From: Alan Story <Alan.Story@hertfordshire.gov.uk>
Sent: 10 June 2019 14:05
To: William Myers
Subject: RE: Northaw Place, Coopers Lane - 6/2019/0918/HOUSE

From: William Myers <w.myers@welhat.gov.uk>
Sent: 10 June 2019 11:50
To: Alan Story <Alan.Story@hertfordshire.gov.uk>
Cc: Paul Marshall <Paul.Marshall@hertfordshire.gov.uk>
Subject: Northaw Place, Coopers Lane - 6/2019/0918/HOUSE

Drg. No
747 / SP3

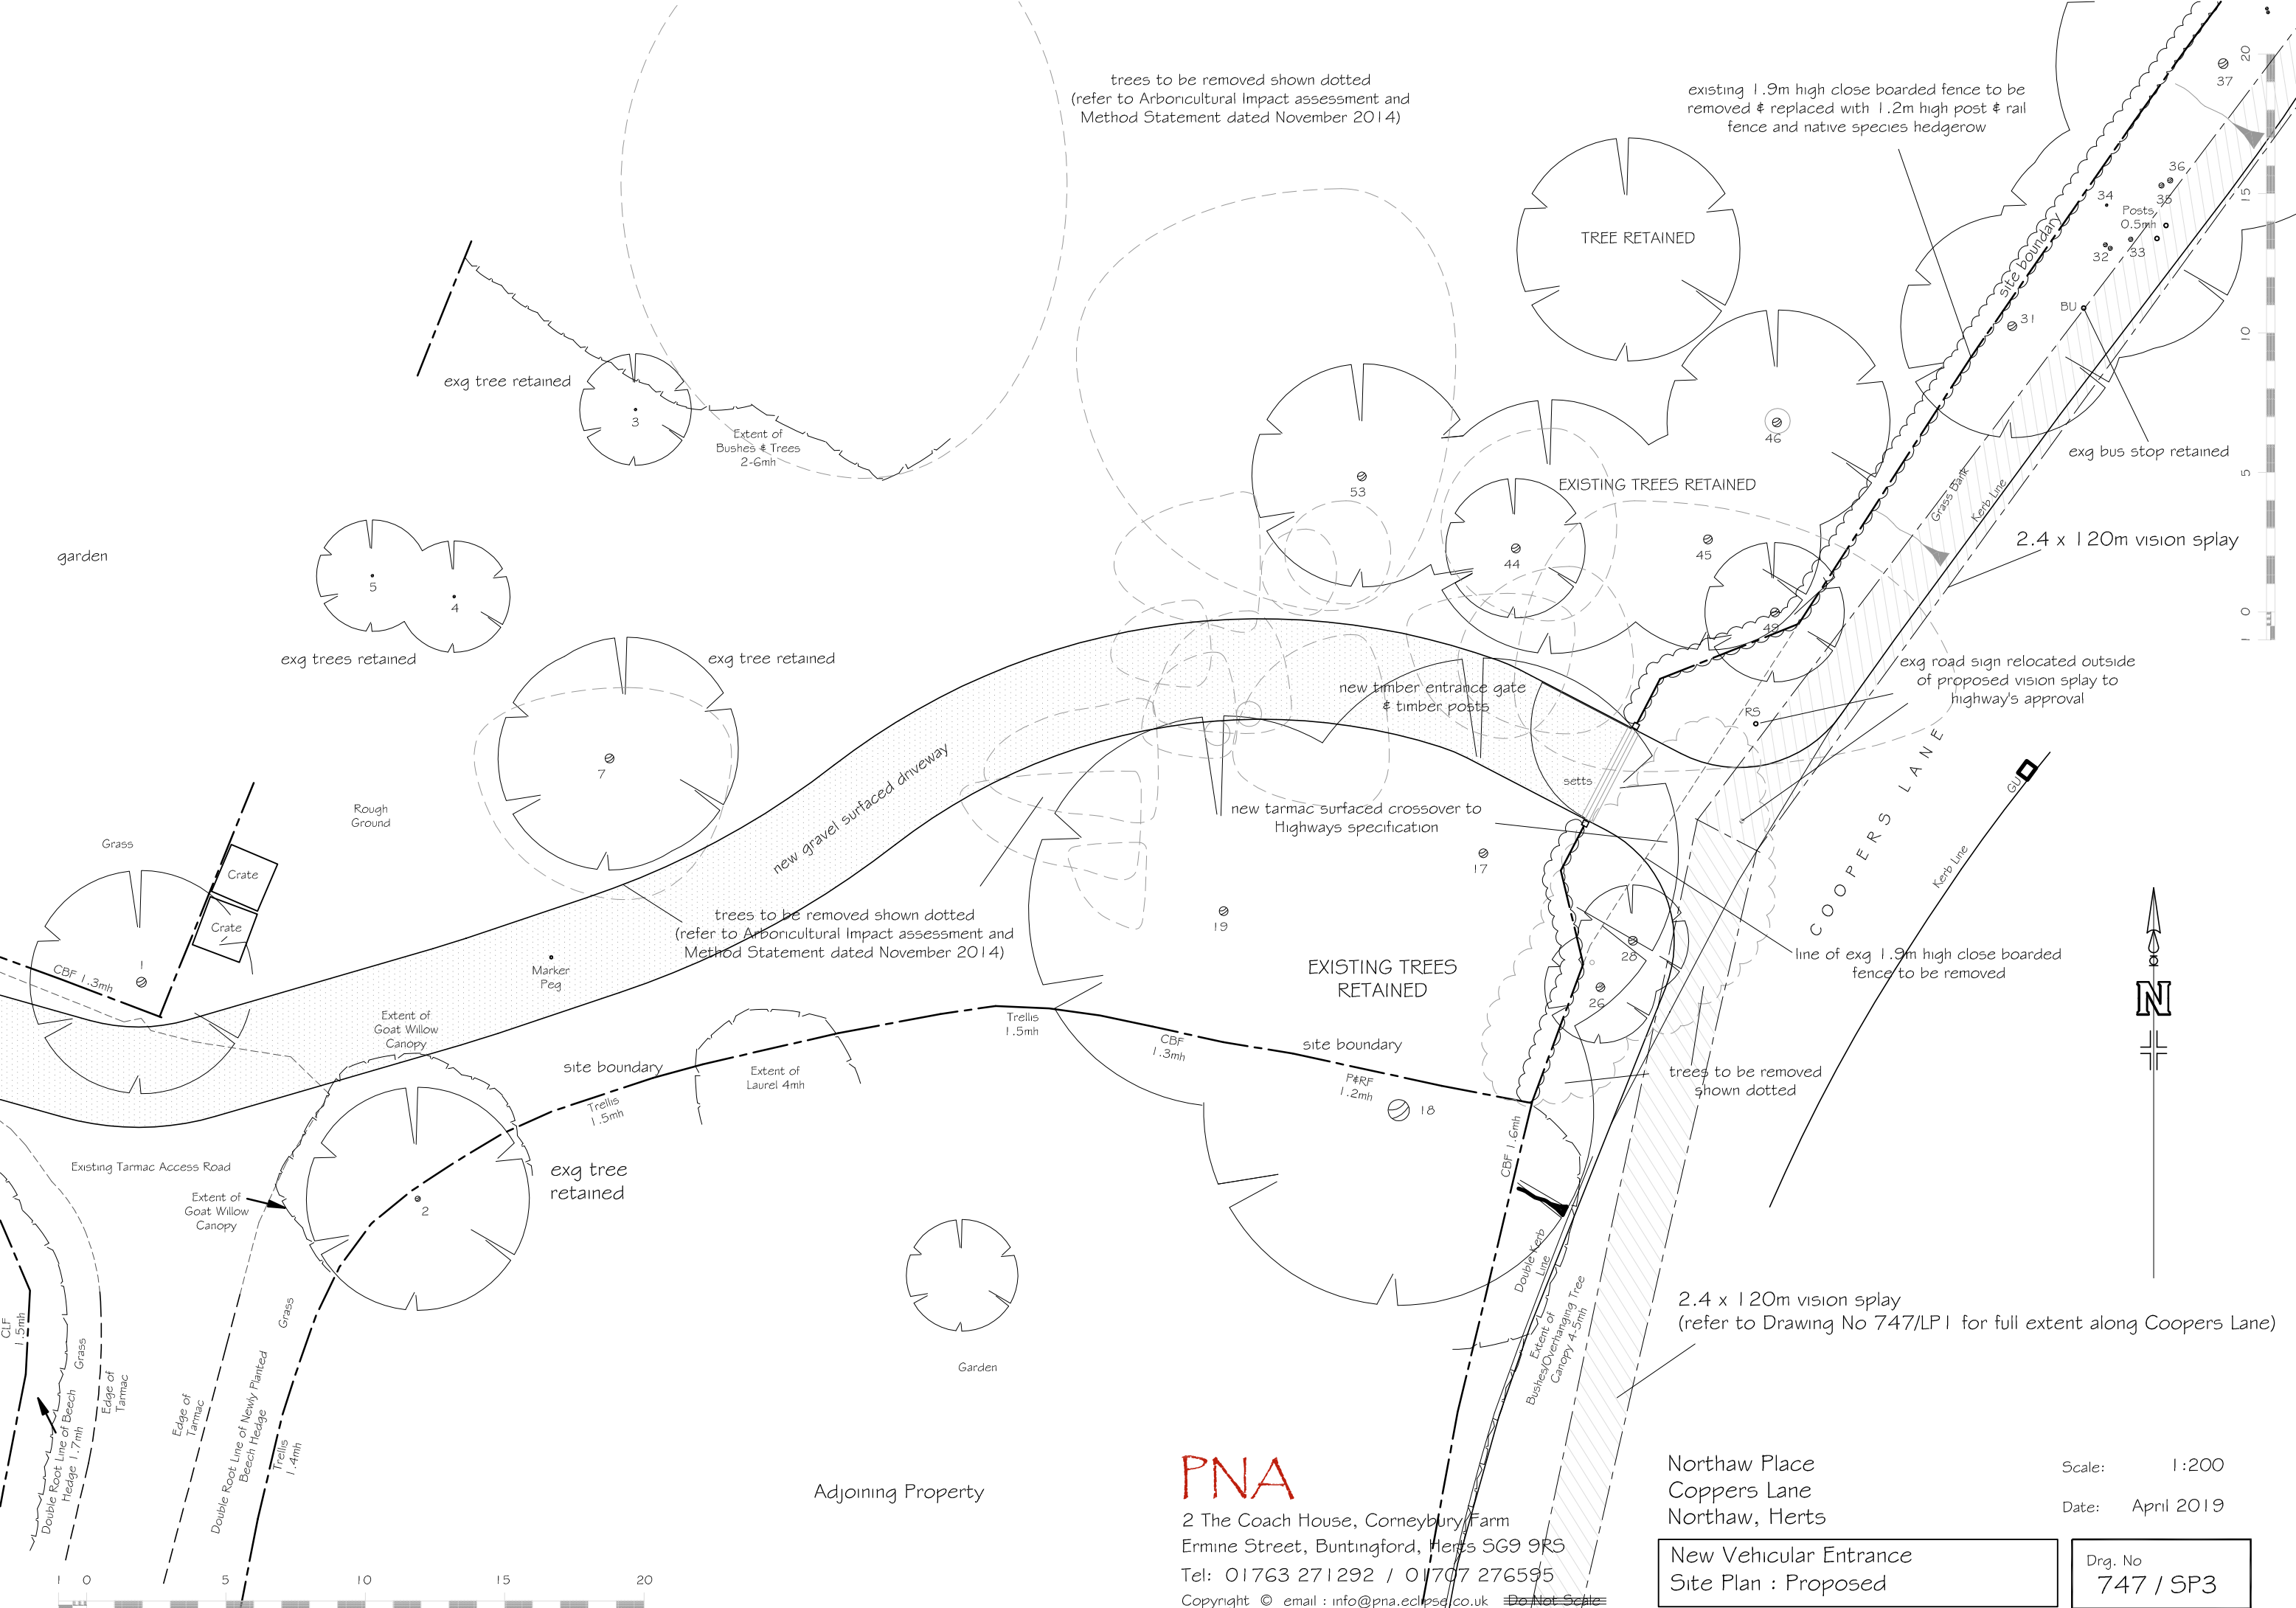
Having reviewed this – I present a concern that the detail shown in drawing 747/SP3 is not sufficient. The use of 1:200 scale in providing visibility splays means that the necessary visibility over the full 120m is not shown. Specifically, I have a concern that visibility to the NE fails to have regard to the affect of planting, particularly the large tree shortly to the north on the opposing side. Particular concern is voiced that whilst MfS suggests that some interference within a visibility splay is not necessarily unacceptable, the effect of the forward radius of Coopers Lane means that vehicle approaching the site from the north may be obscured over much of the distance necessary for vehicles to see each other and take appropriate action.

The applicant should provide plans that indicate that visibility from the access to approaching vehicles is not prevented as a result of trees within the street scene, or demonstrate the extent to which the tree shall obscure vehicles as they approach the access, currently I am concerned that visibility in this direction is significantly constrained over a notable distance. The applicant should note that the County Council does not support the removal of street trees unless they are dead, dying, diseased or damaged. I have no evidence that any of these criteria are met in terms of the tree in question.

No objection, in principle is offered to the resiting of the advance signage indicating the right hand bend, noting that space exists elsewhere within the highway limit. The width of the access and internal driveway is insufficient to enable vehicles to pass each other clear within the site, with no opportunities for passing provided.

Plan 747/SP3 identifies 'new timber entrance gate and timber posts' notation, but no gates are shown. Assuming this is located at the position of the setts, then this is 6m inset from the carriageway edge, but there is no information shown on the form of the gates. The HA would require gates to open internal to the site, or would need to provide even greater set back from carriageway edge to enable their operation without a vehicle being forced to wait in the carriageway.

I would observe that presently the four dwellings off Northaw Place, shared access (existing) provides opportunities for large vehicles to enter the site and turn such that they may leave in forward gear – this therefore enables refuse collection. No detail on refuse arrangements in this matter are shown. It is unclear whether the dwelling to which this new access is proposed shall continue to be served by the existing arrangement, or whether it is proposed that it shall operate completely independent from existing arrangements, in which case details of where bins will be stored / collected should be confirmed and should have regard to the maximum carry distances defined in the appropriate guidance.

I do not consider that the submitted plans sufficiently demonstrate to the satisfaction of the Highway Authority that the proposed access is provided in a safe manner, and recommend that the application be refused as it introduces an unsafe access on a classified road contrary to the County Councils Local Transport Plan Policy 5.
